Description of Works: Approval of reserved matters following outline consent
LU/229/10/ for appearance, landscaping, layout & scale for 84
No. dwellings

PLANNING REF: LU/201/16/RES – WINDROOS, LITTLEHAMPTON

AMENDED APPLICATION - CONSULTATION RESPONSE

**COMMENTS FROM NIGEL BALDWIN - 22 March 2017- HOUSING STRATEGY
AND ENABLING MANAGER – ARUN DISTRICT COUNCIL**

CLIENT	Stuart & Marcia Lyons
PROJECT	Windroos, Littlehampton
TITLE	House Type A (AH22) & HOUSE TYPE B (PH22)

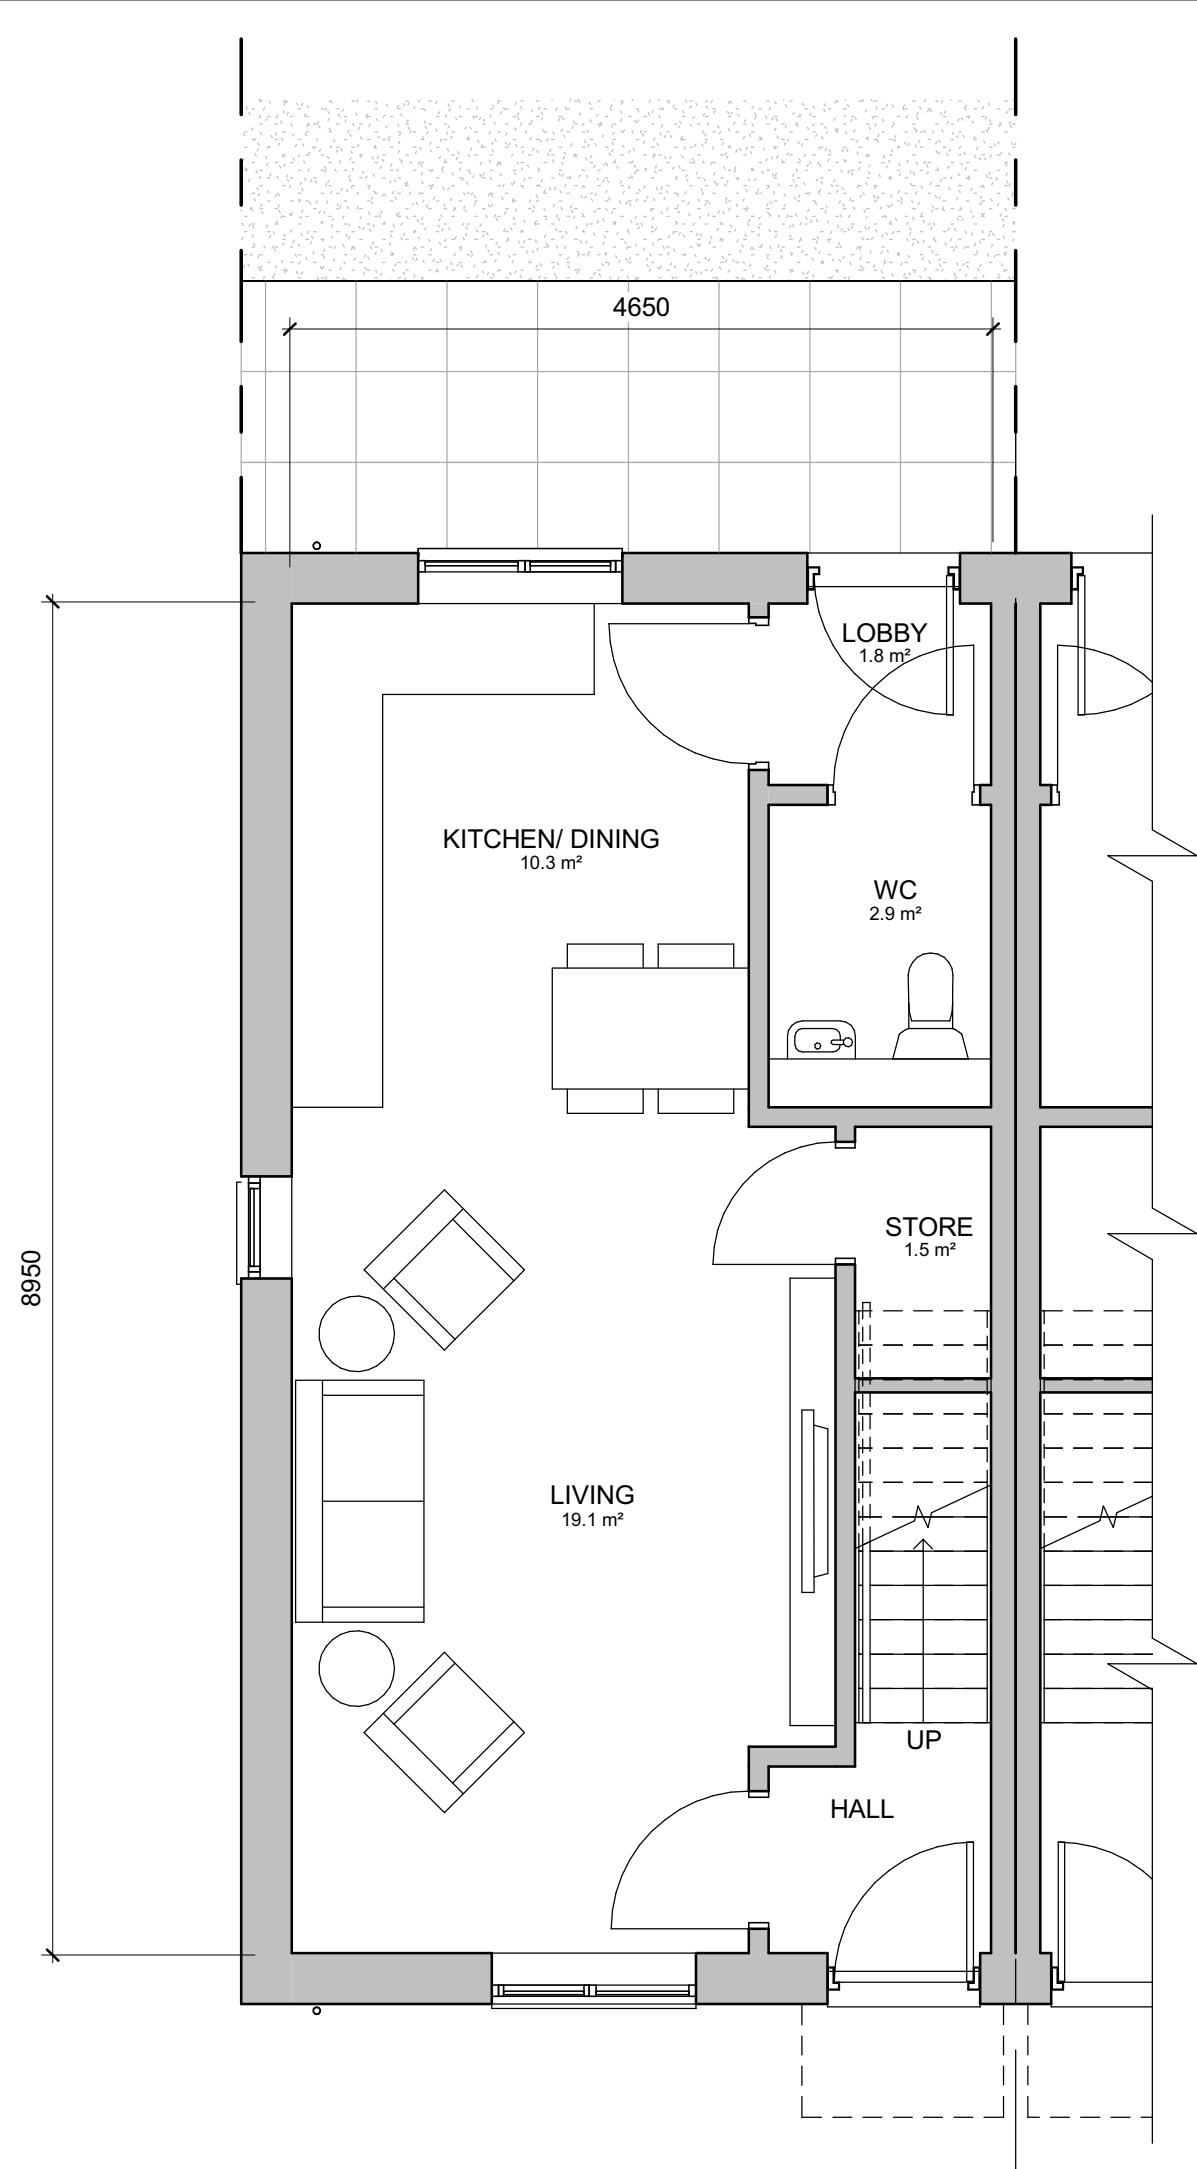
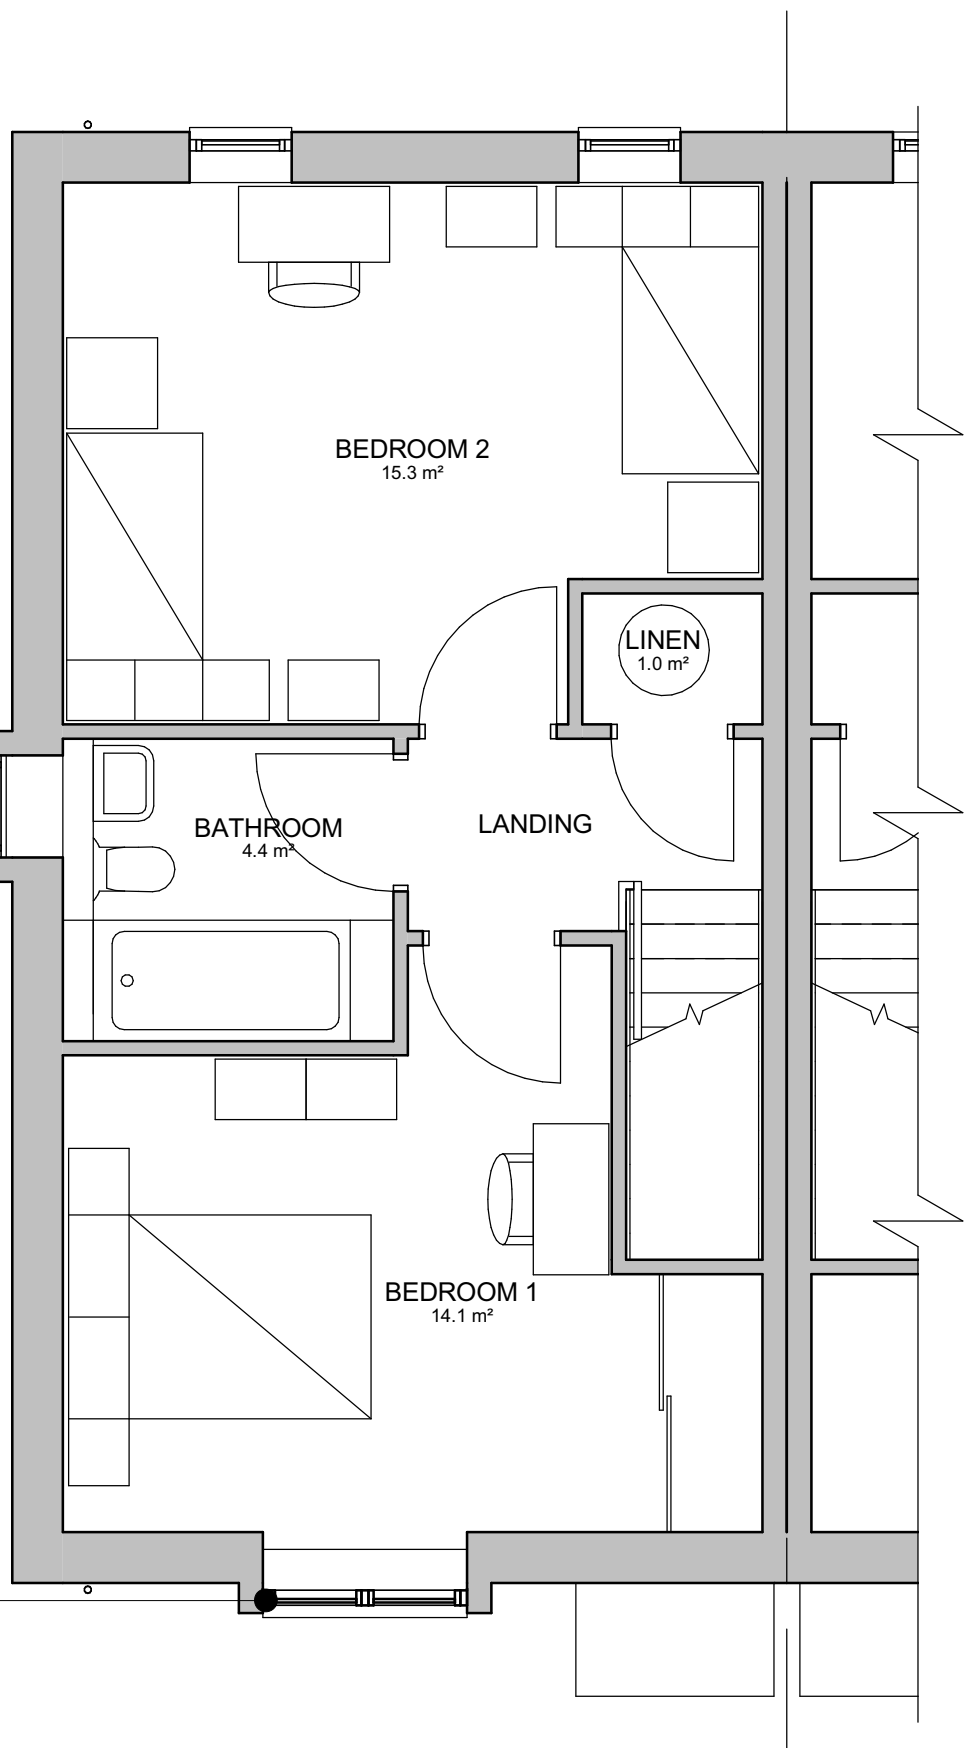
- The applicants should continue to engage with one of the Arun preferred providers of affordable housing in order to deliver the affordable housing.
- There appears to be very little space around the bed in Bedroom 1 of the 2 bed flats &
- The open plan nature of the kitchens in the 2 bed properties does not allow them to be secured and this can be a safety issue.
